Case Officer: Simon Newall

Applicant: Bicester Gateway Ltd

Proposal: Reserved Matters to 16/02586/OUT - Access, layout, scale, appearance and landscaping details for Phase 1B for up to 12 No knowledge economy units in Use Class E (former Use Class B) (14,972 sq m gross external area) with associated parking, landscaping, utilities and access

01 Type 1 - Elevation and Plan View
SOFT LANDSCAPE TREE PIT DETAIL WITH STAKES

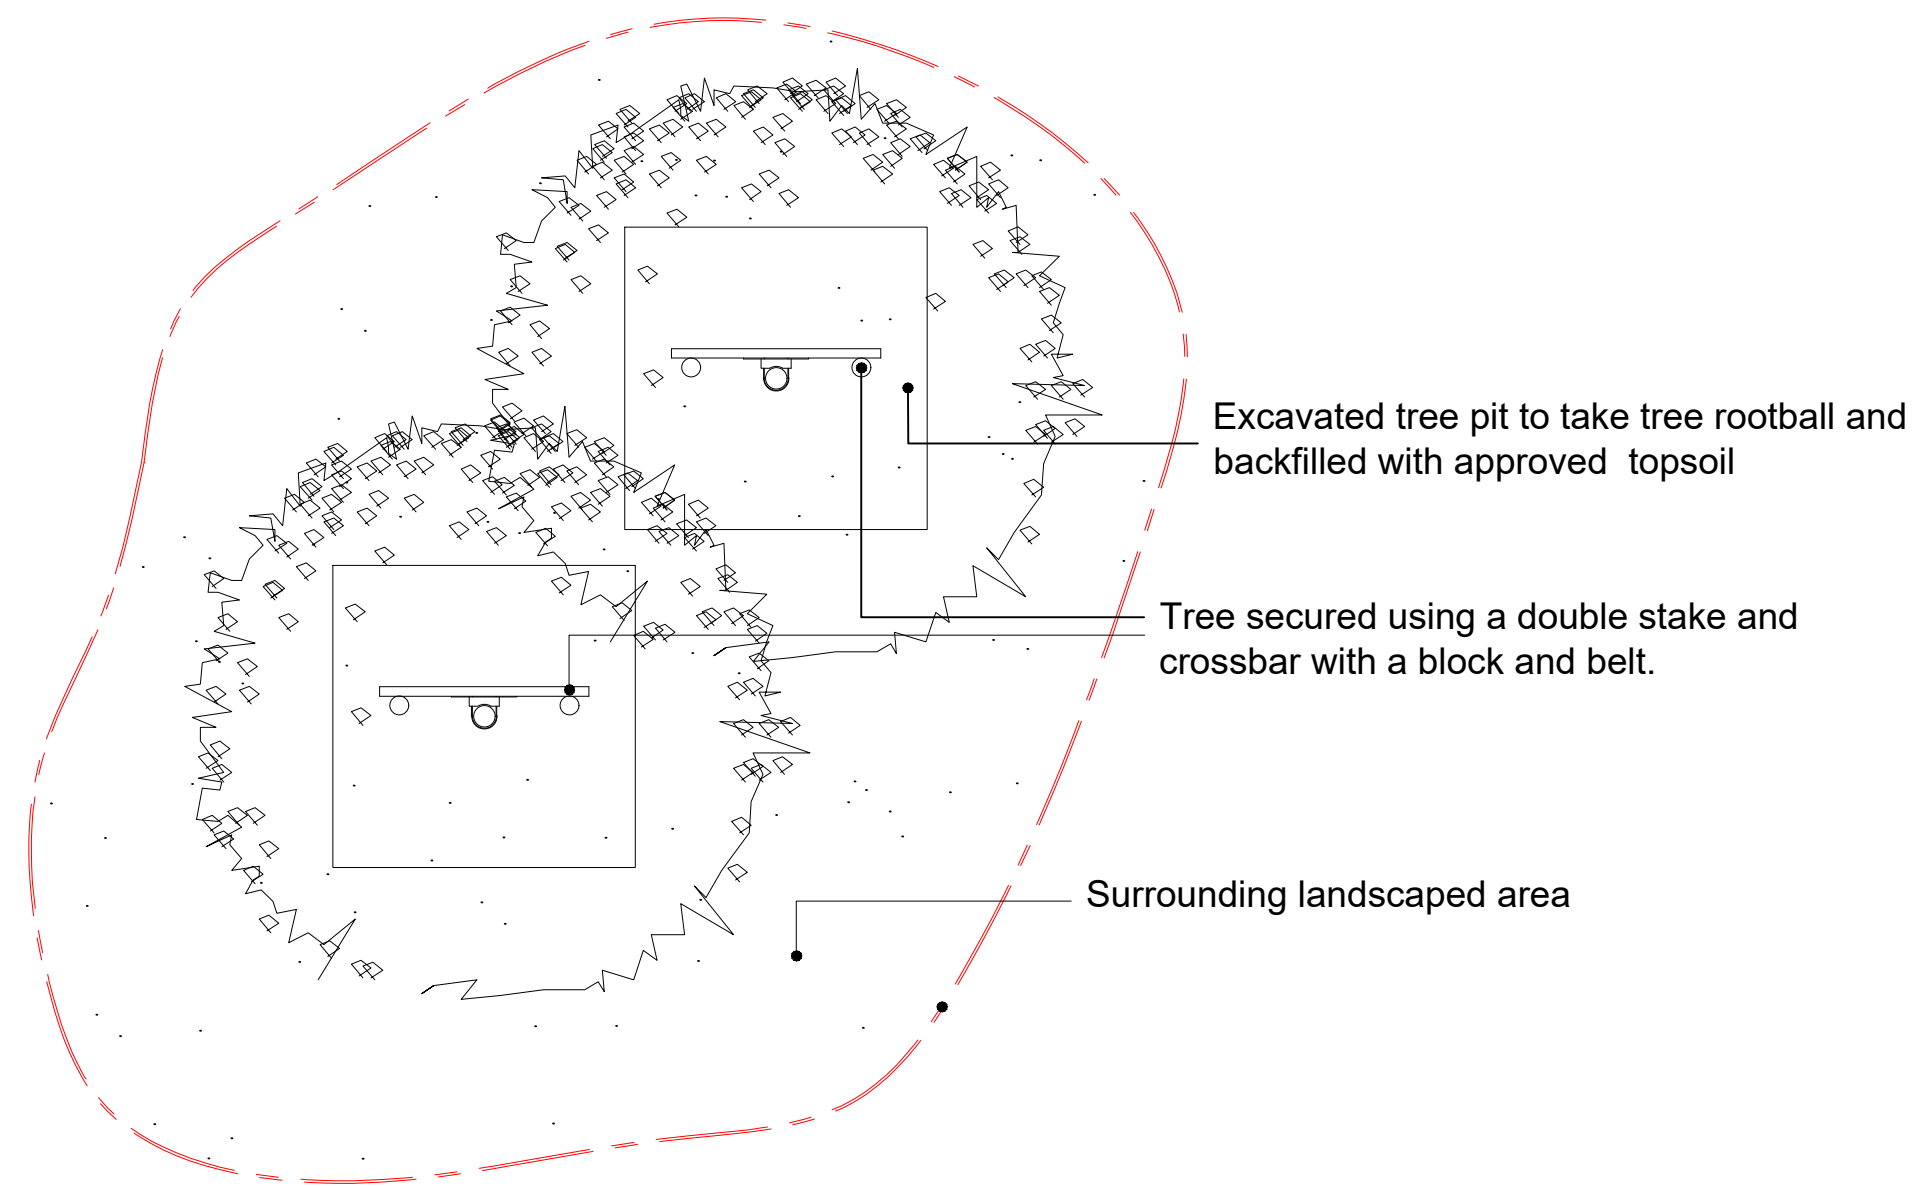
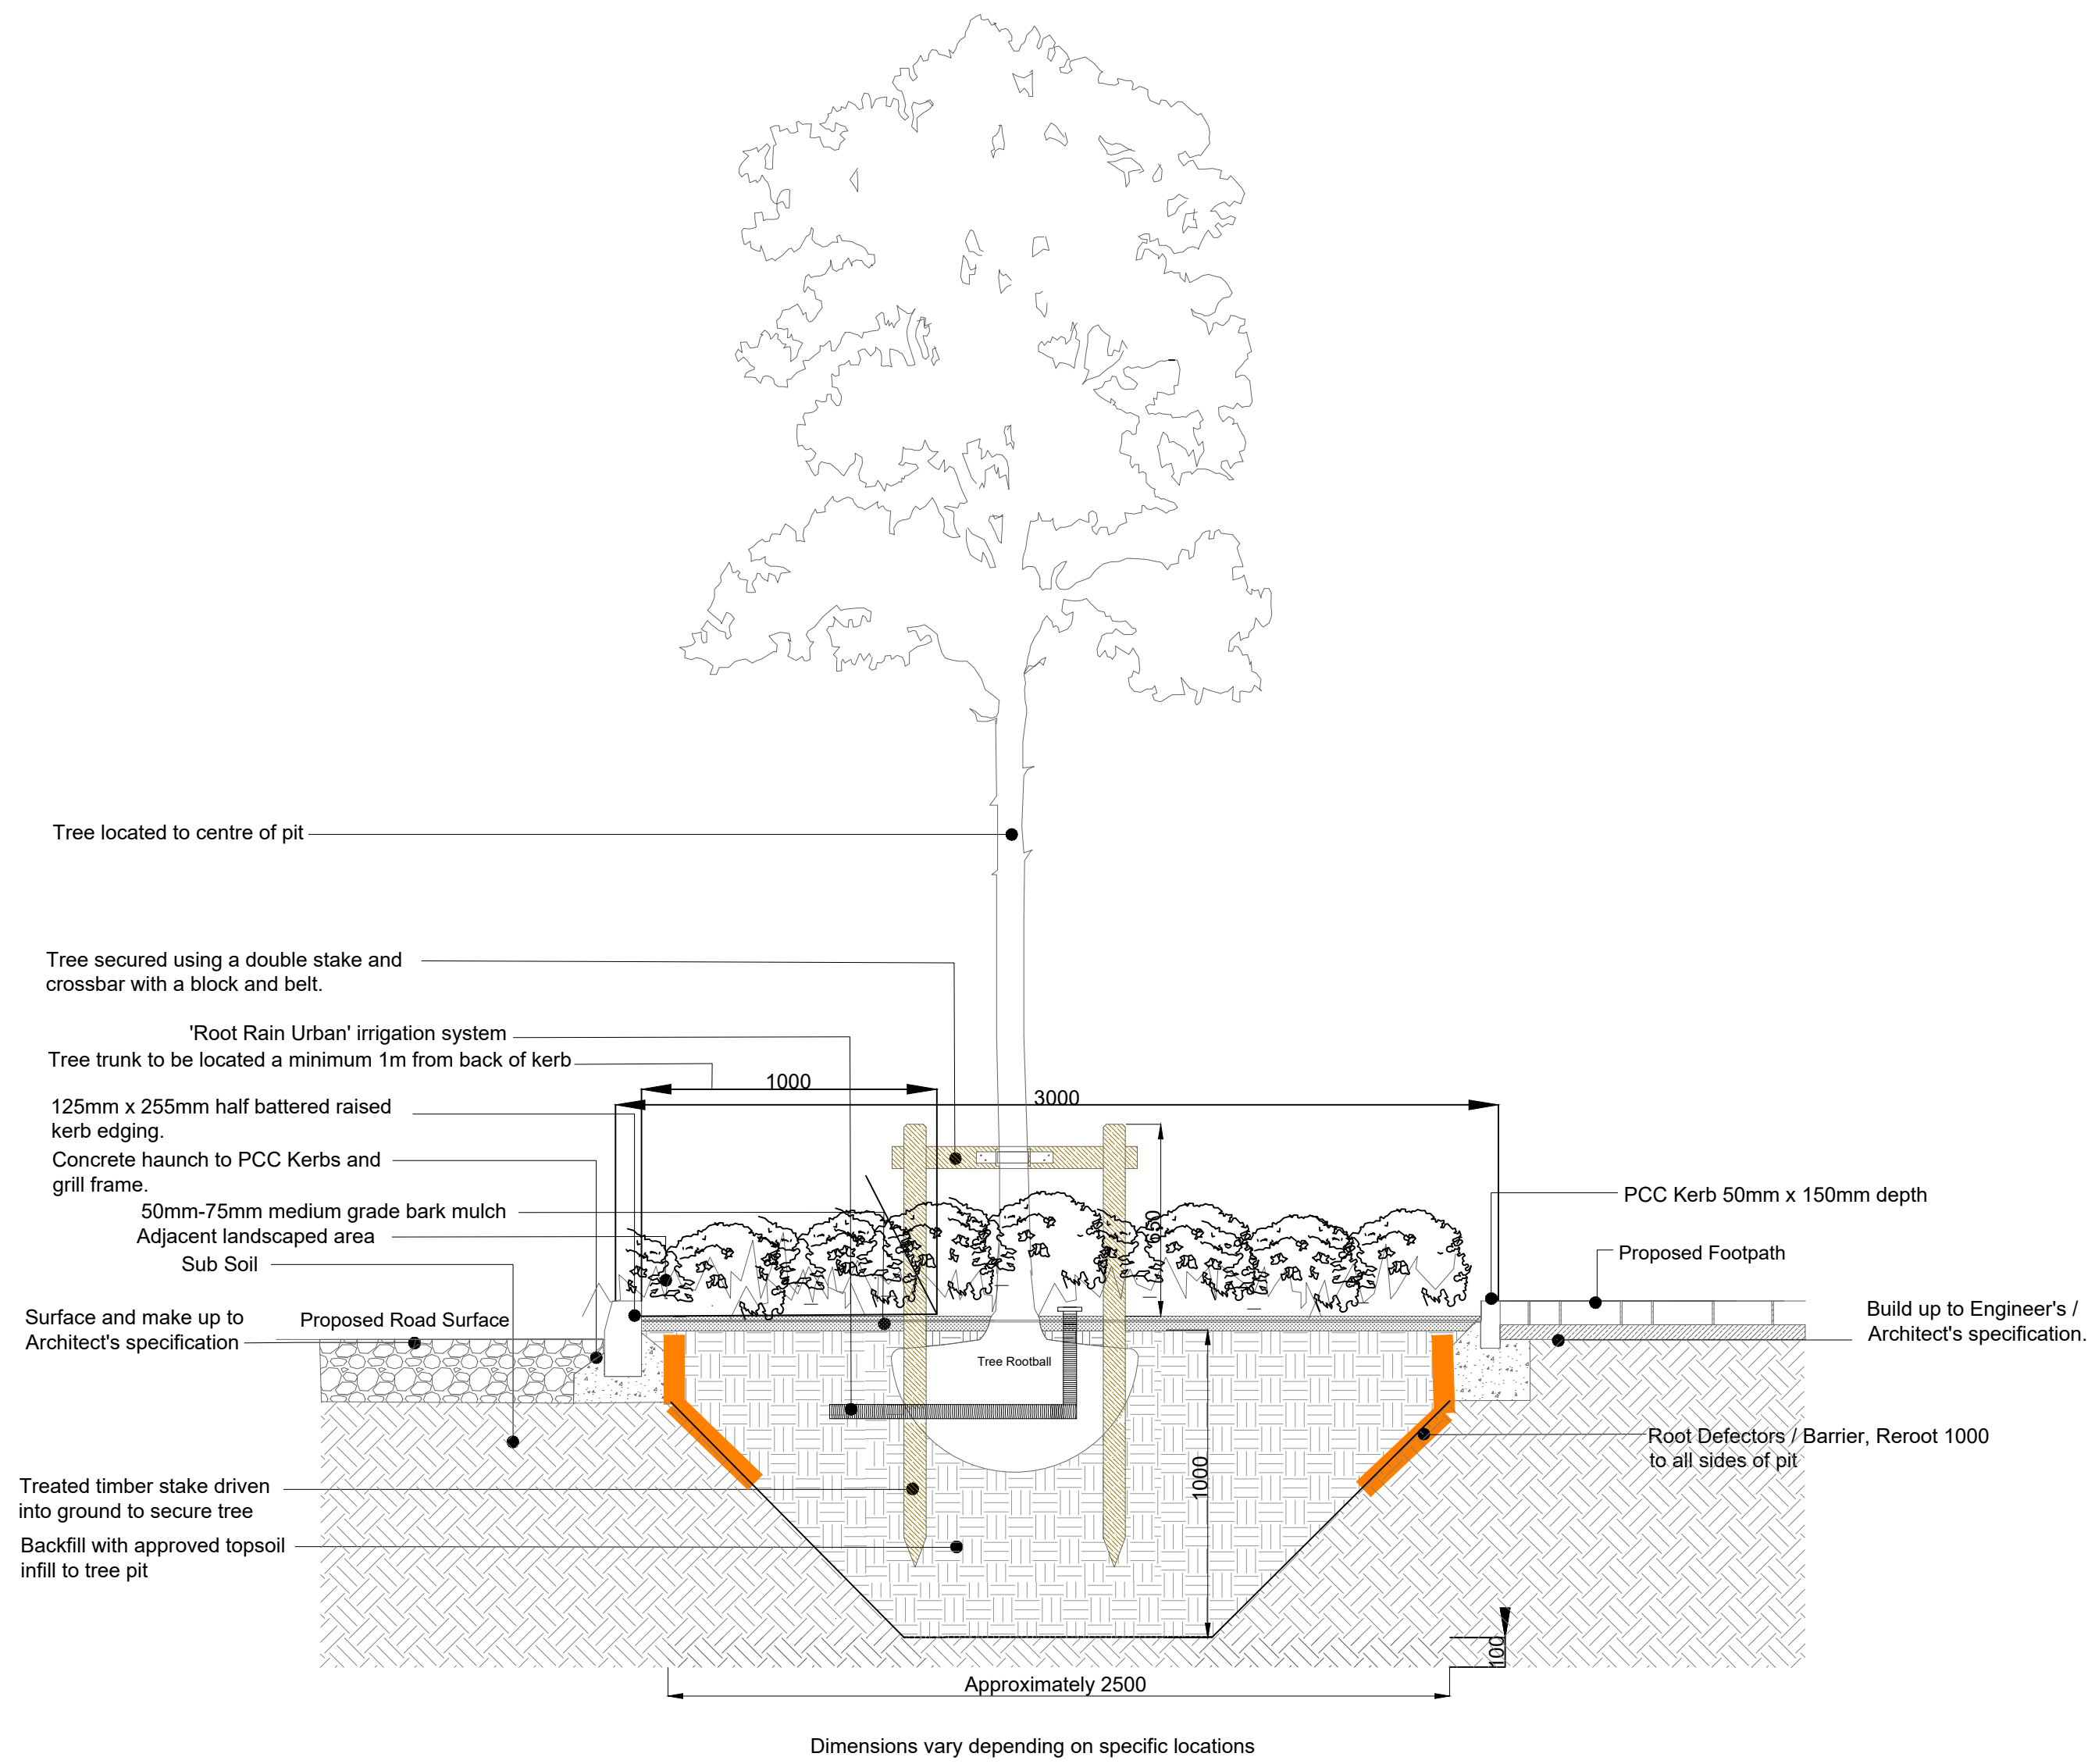
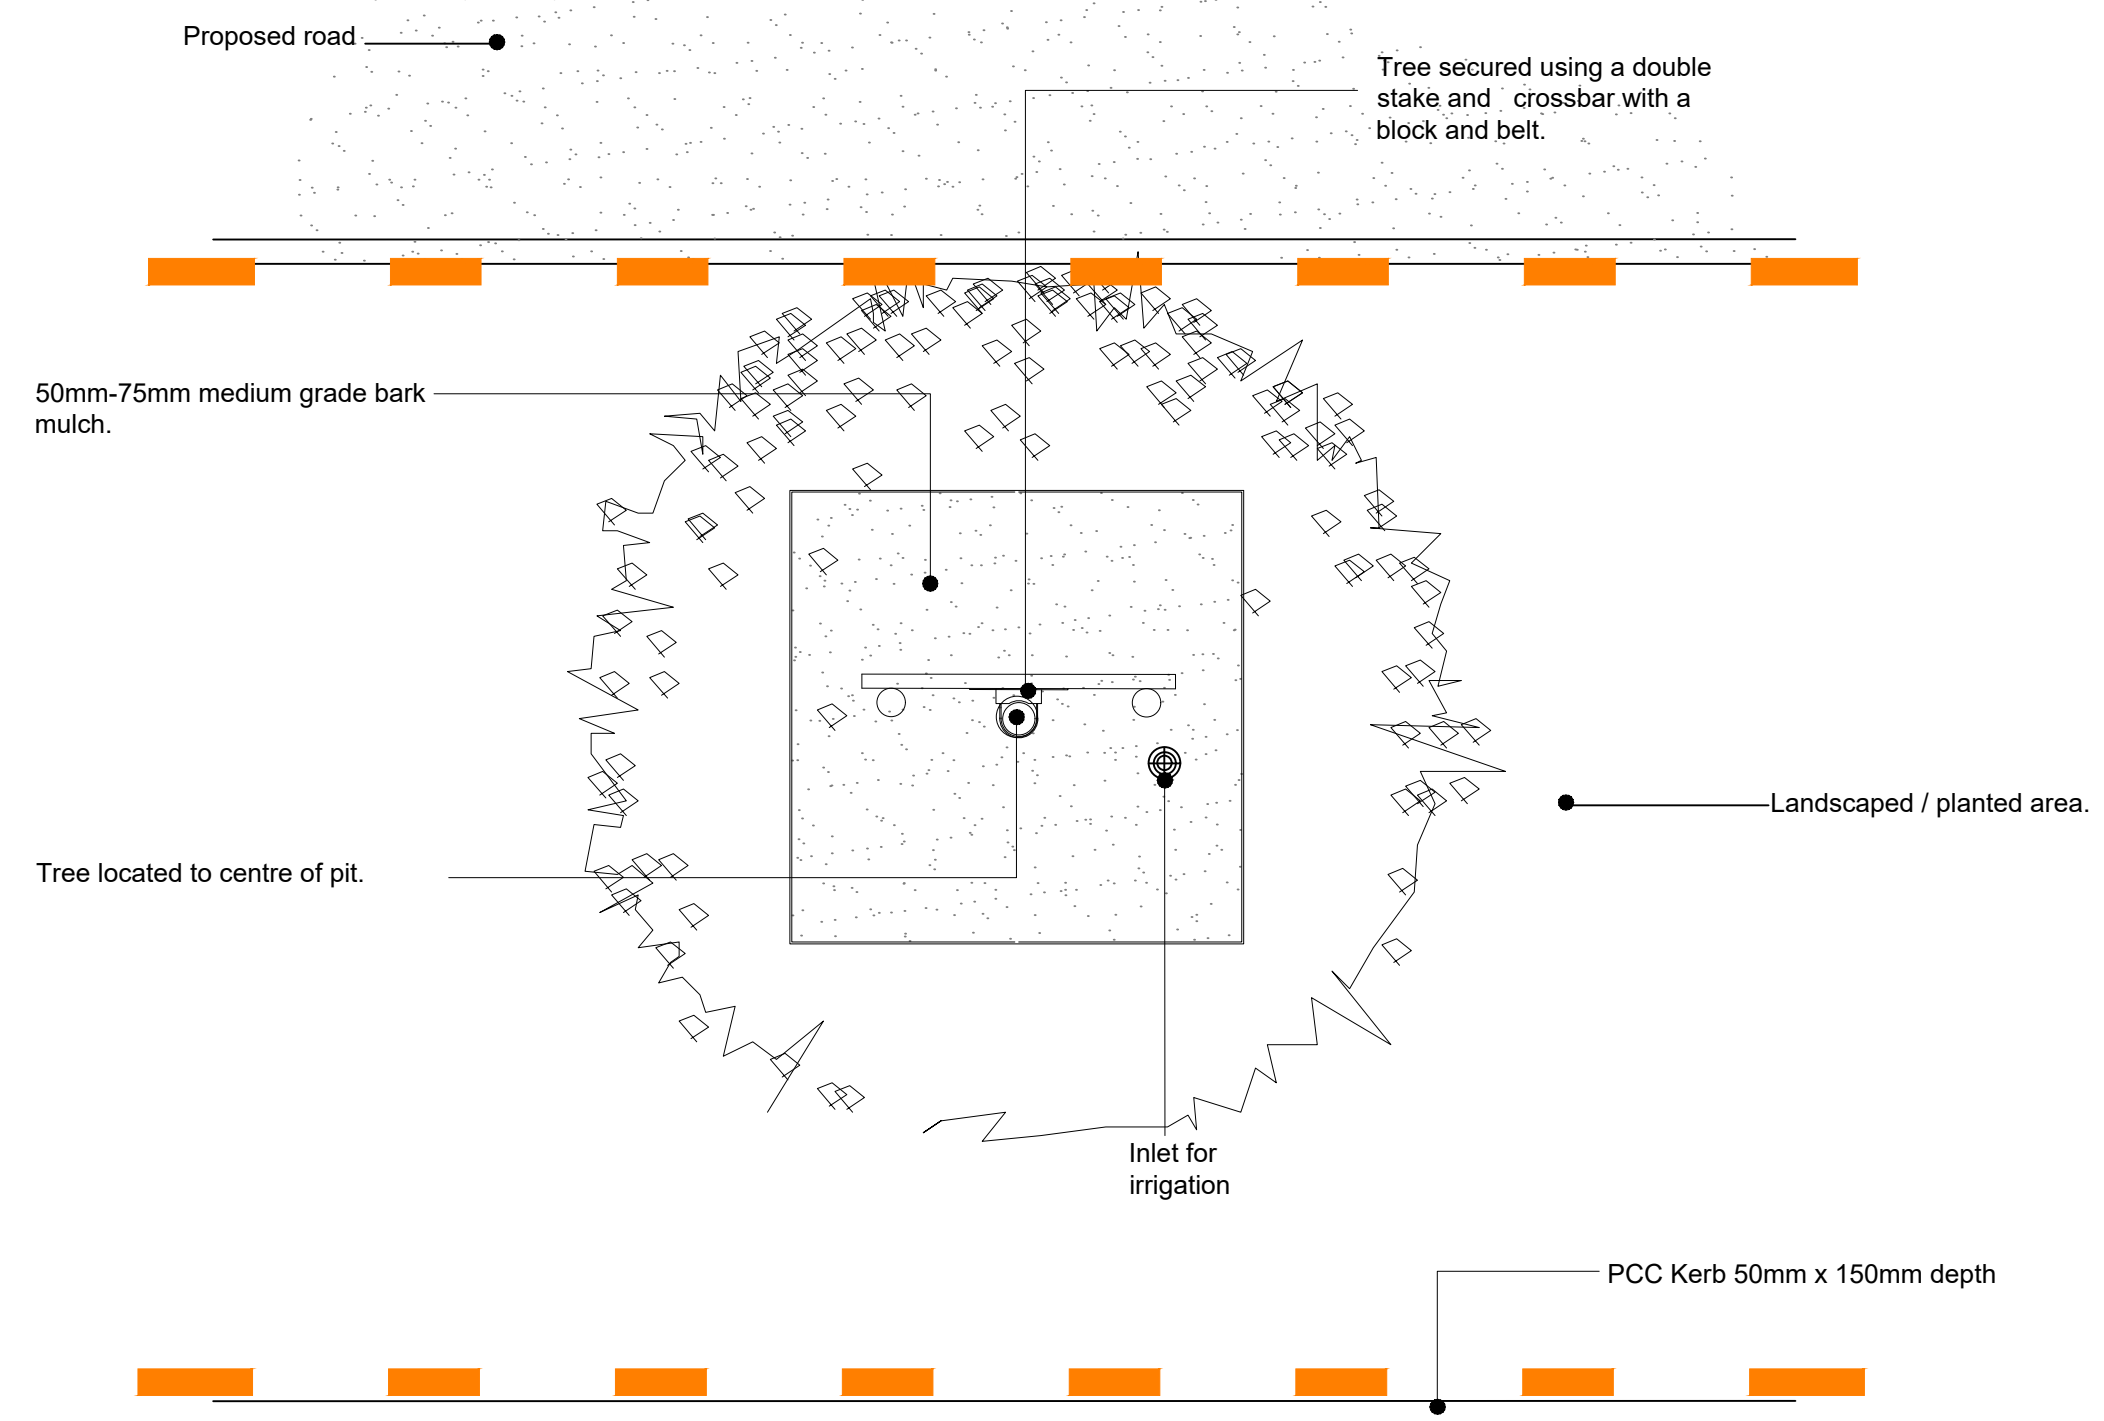
- Tree pits: The space for tree growth between the kerbs is limited, because the haunching is usually substantial to prevent future structural damage to surfaces. If these corridors can be widened all the good. Root deflectors will need to be installed anyway. Linear tree pit should be used to ensure successful planting of establishment of trees. Individual trees in single pits are not as successful. Further detail is required.

- Indication of tree pit details and root deflectors on the relevant plans, with tree clearly set out within the planting plans on mounding and elsewhere.
